Development Application Permit Review

June 21, 2019

Name:	Creekside at Lorson Ranch Filing No. 1 Final Plat	Application Type:	Final Plat
PCD Reference #:	SF-1913	Total Acreage:	83.09
		Total # of Dwelling Units:	235
Applicant / Owner:	Owner's Representative:	Dwelling Units Per 2.5 Acres:	7.07
Lorson, LLC	Core Engineering Group, LLC	Regional Park Area:	4
Jeff Mark		Urban Park Area:	4
212 N. Wahsatch Avenue, Suite 301	15004 1st Ave South	Existing Zoning Code:	PUD
Colorado Springs, CO 80903	Burnsville, MN 55306	Proposed Zoning Code:	PUD

SHEET 2 OF 7

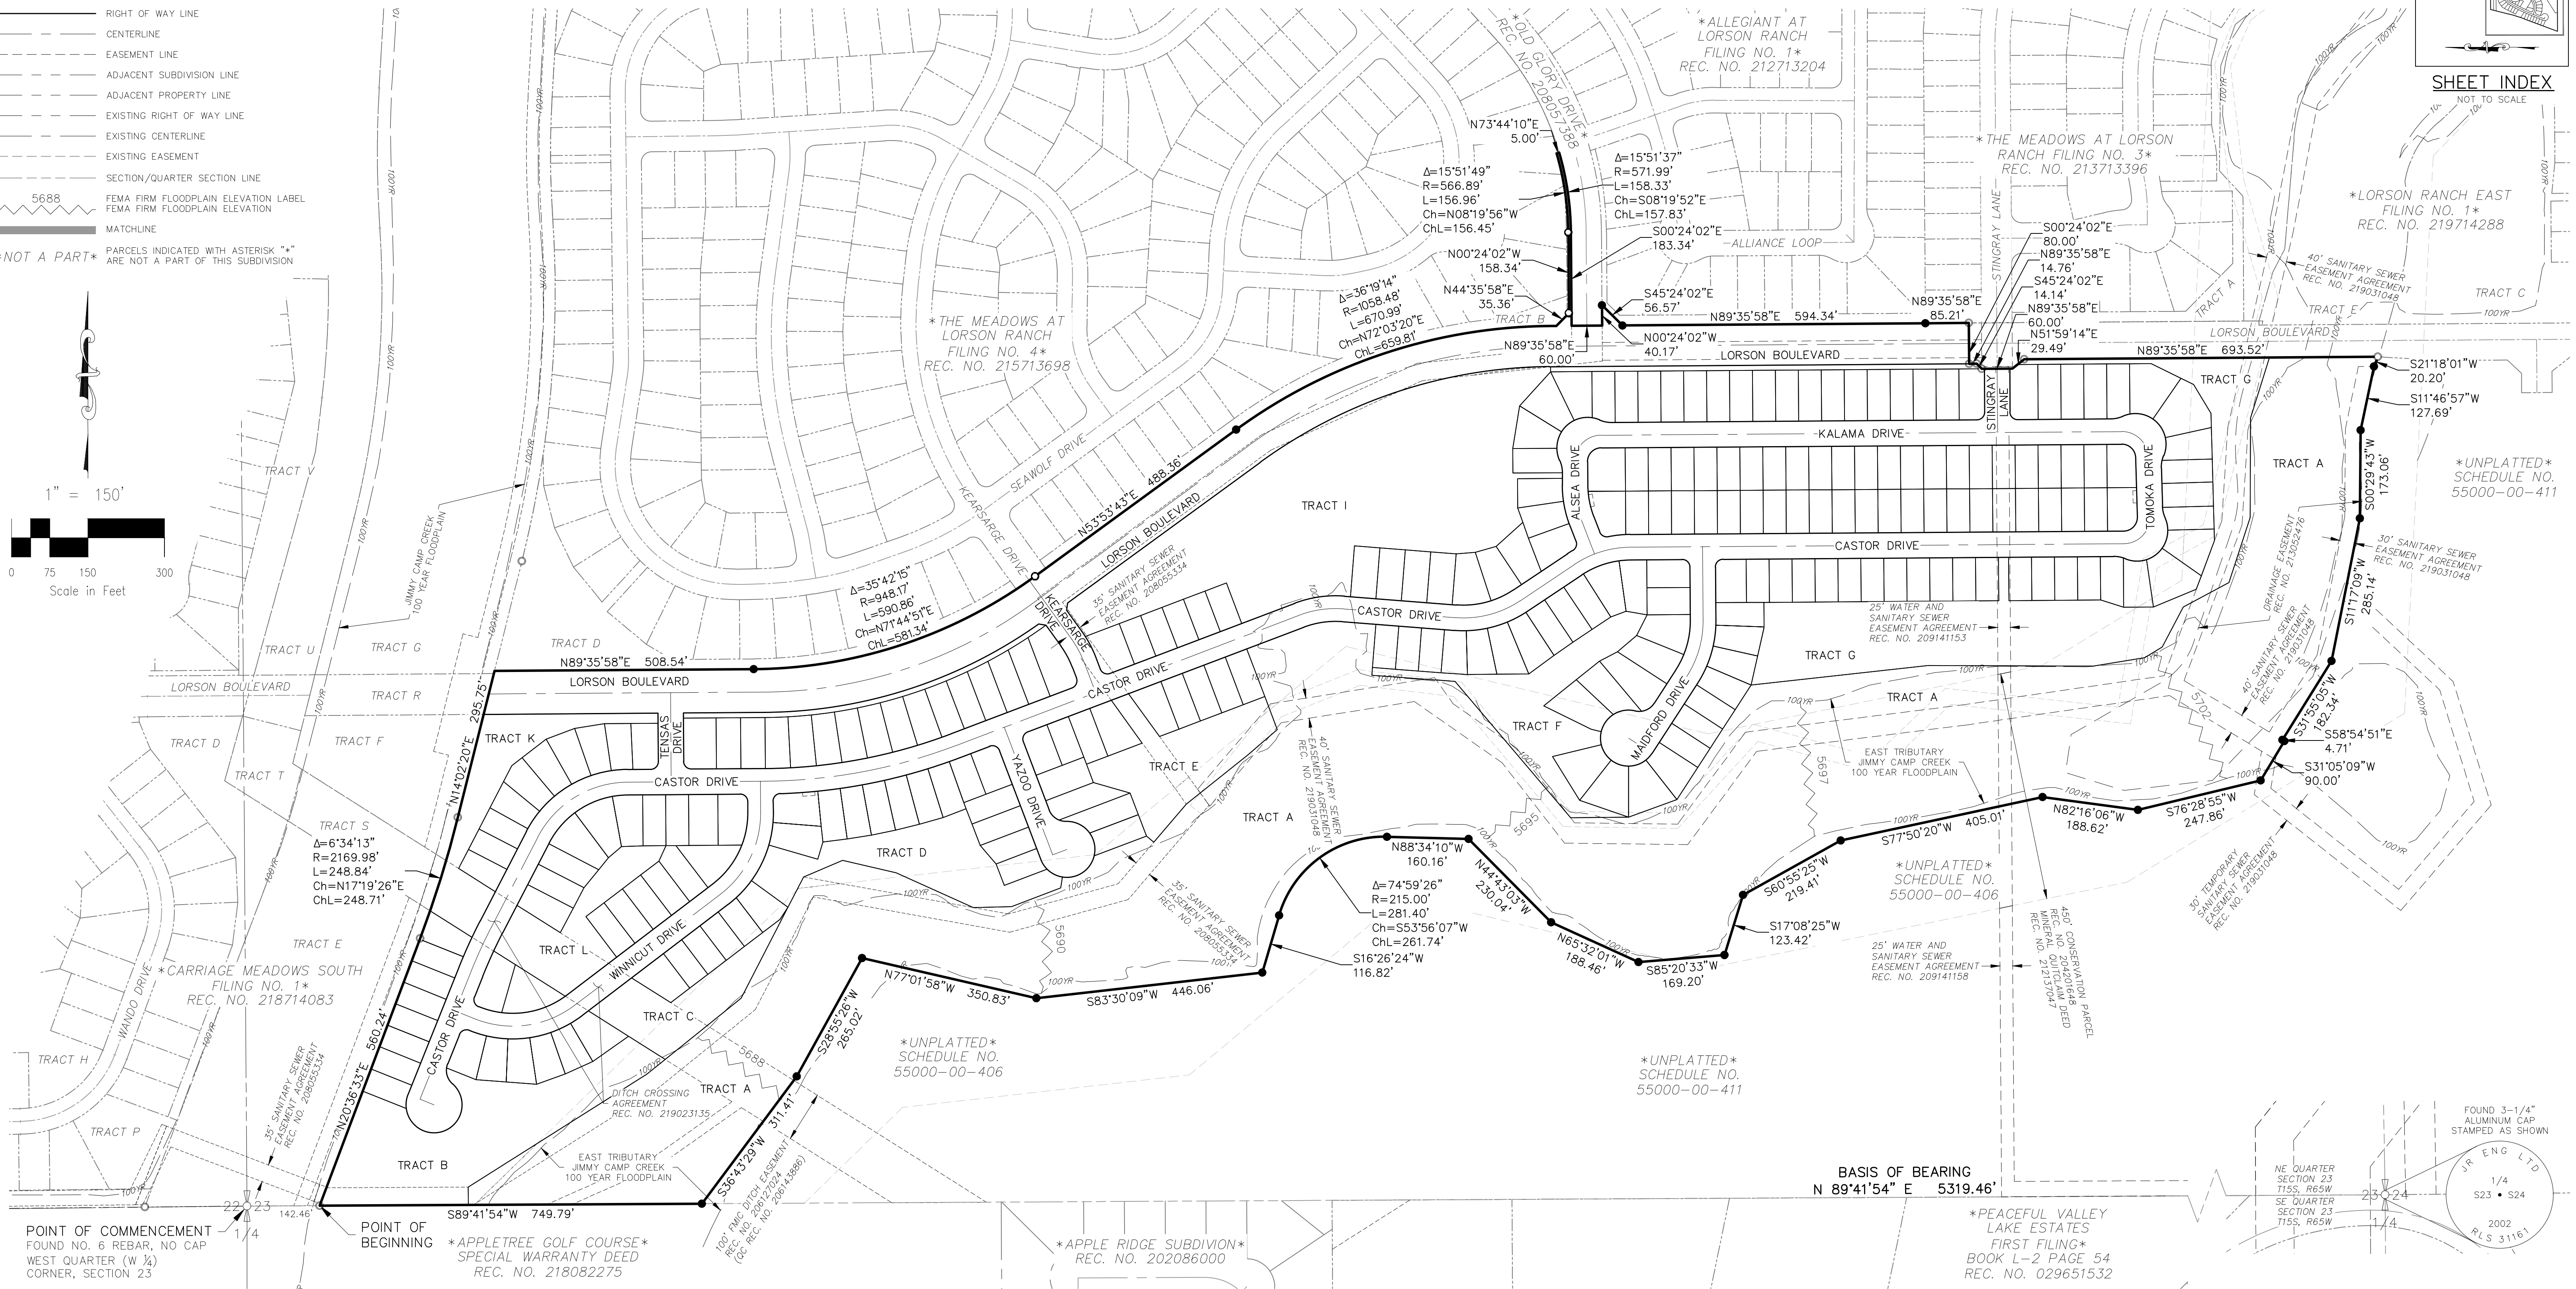
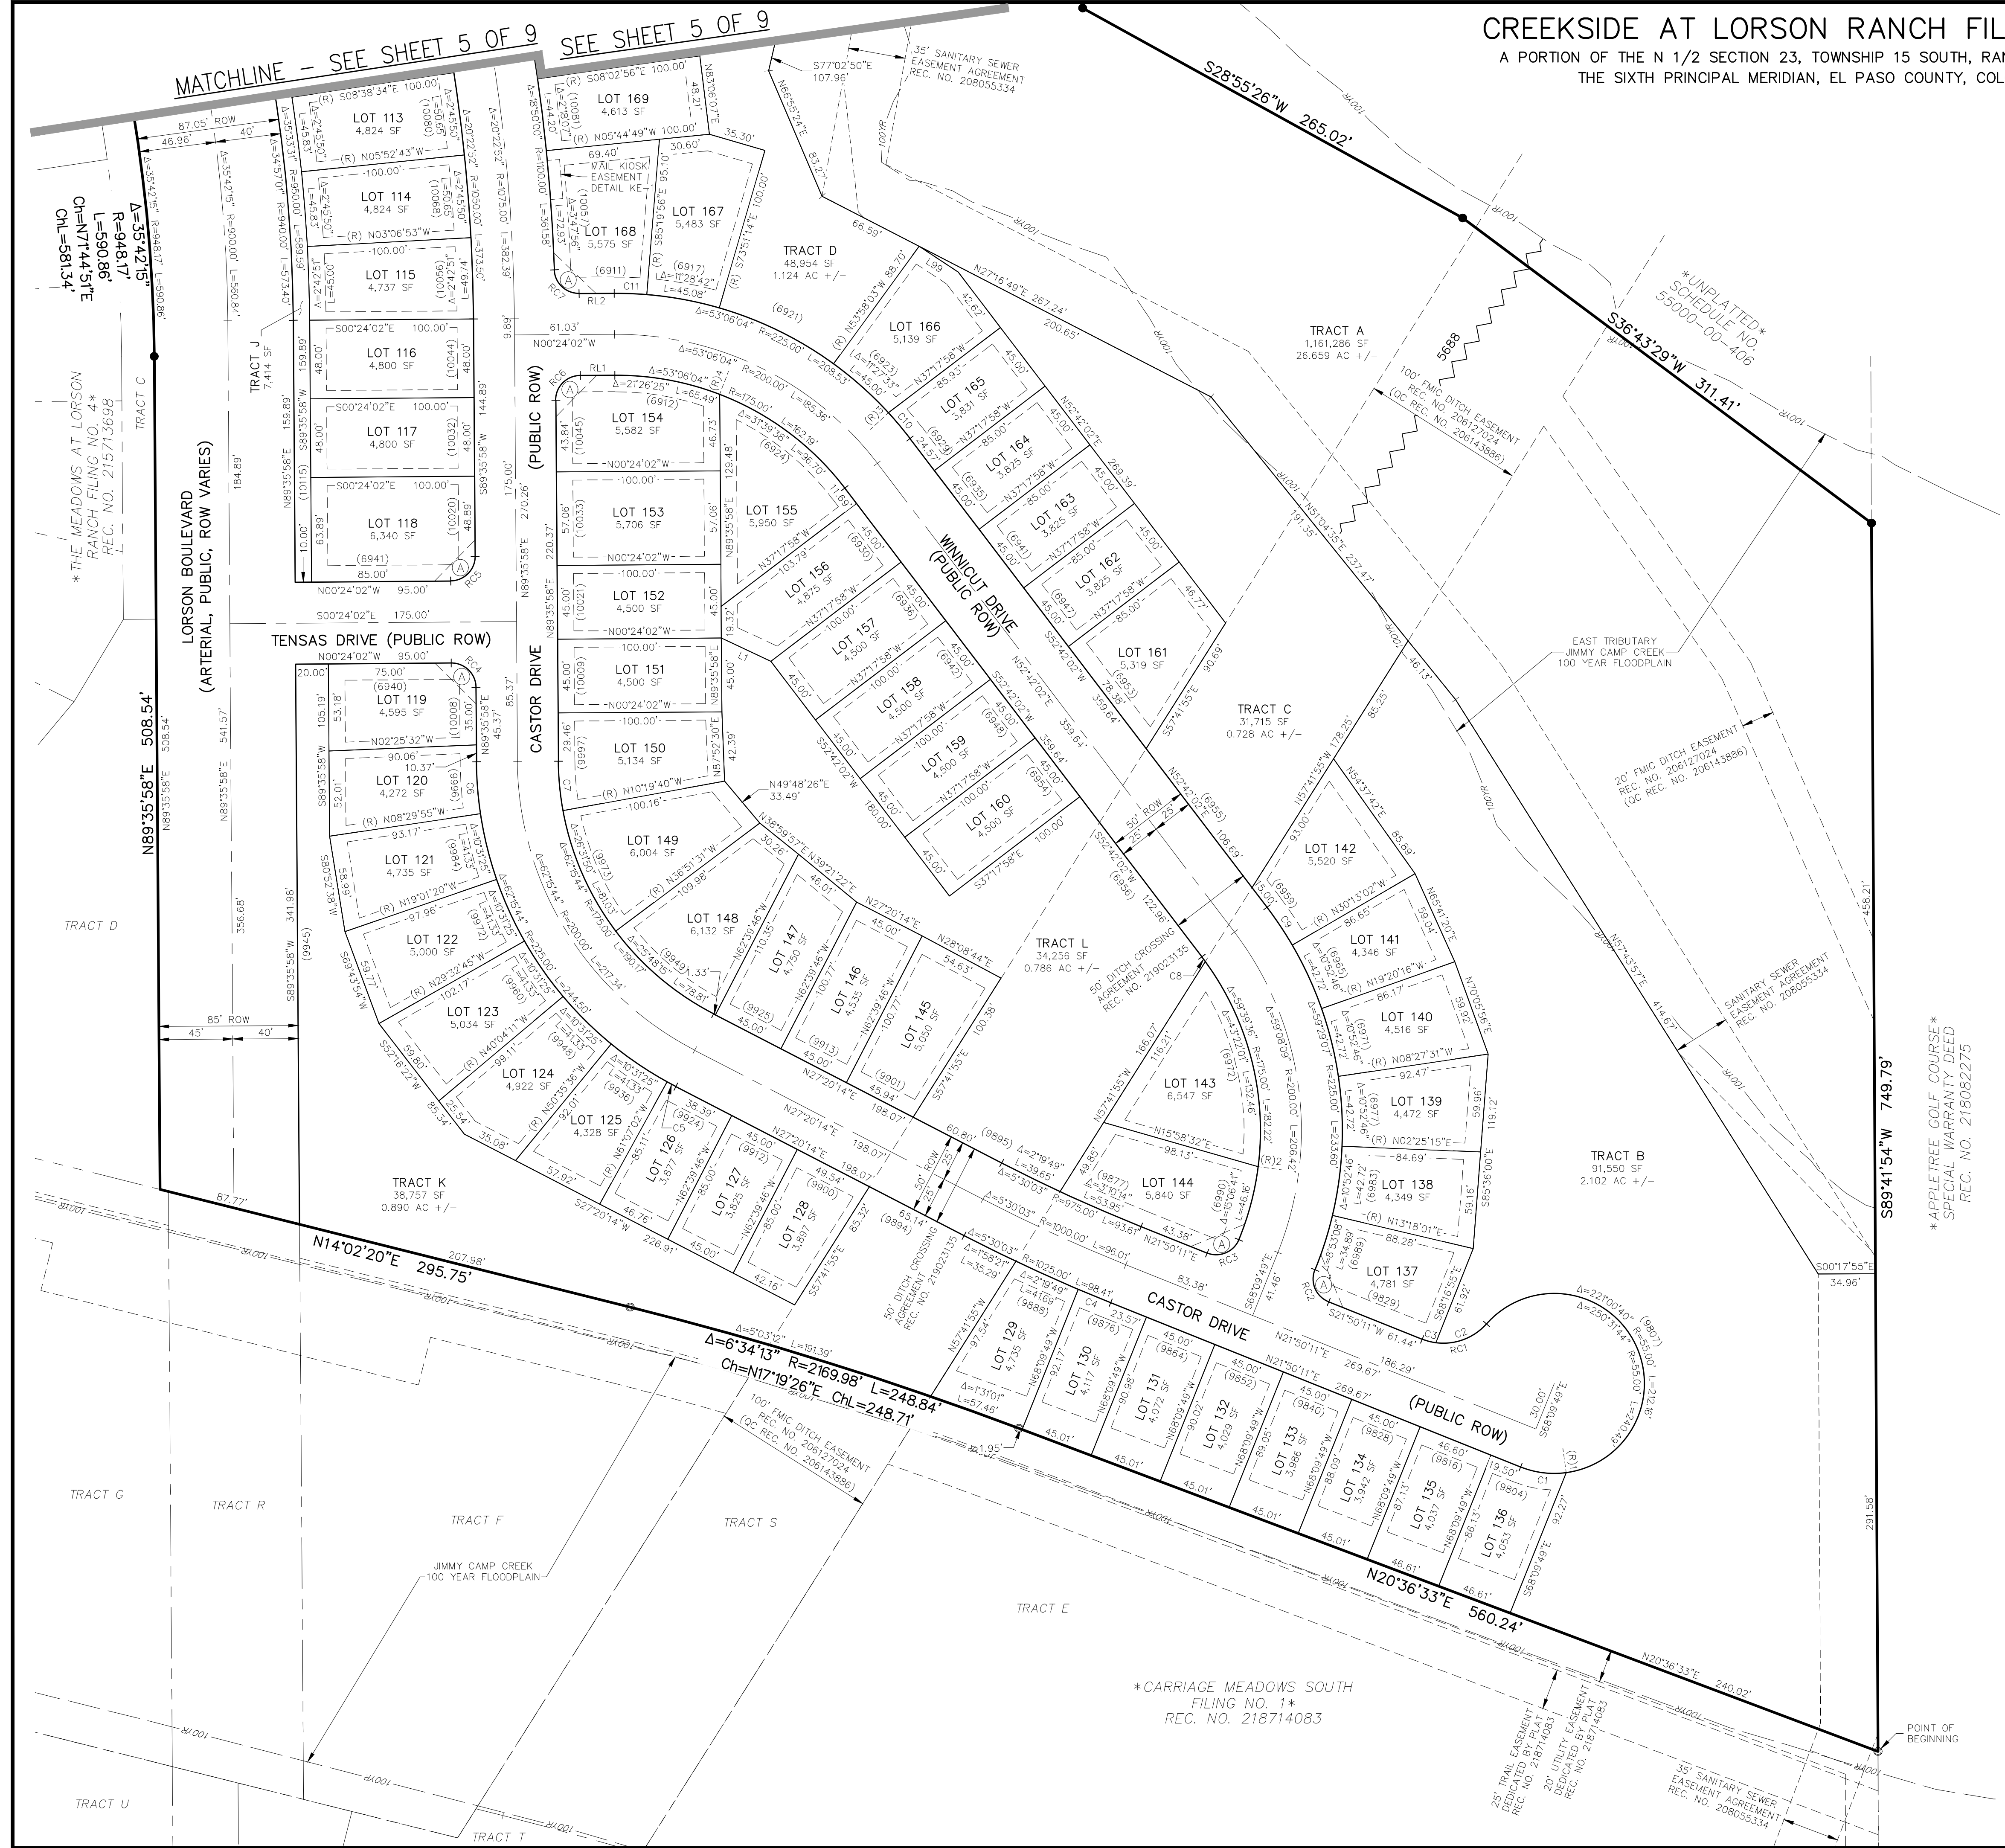
Staff Recommendation: Recommend to the Planning Commission and Board of County Commissioners that approval of Creekside at Lorson Ranch Filing No. 1 Final Plat include the following conditions: (1) show the non-County trails within Tracts A, B, and D on the final plat drawings; (2) Require fees in lieu of land for regional park purposes in the amount of \$107,160 and urban fees in the amount of \$67,680. A park lands agreement may be an acceptable alternative to urban park fees provided the agreement is approved by the County and executed prior to recording the final plat.
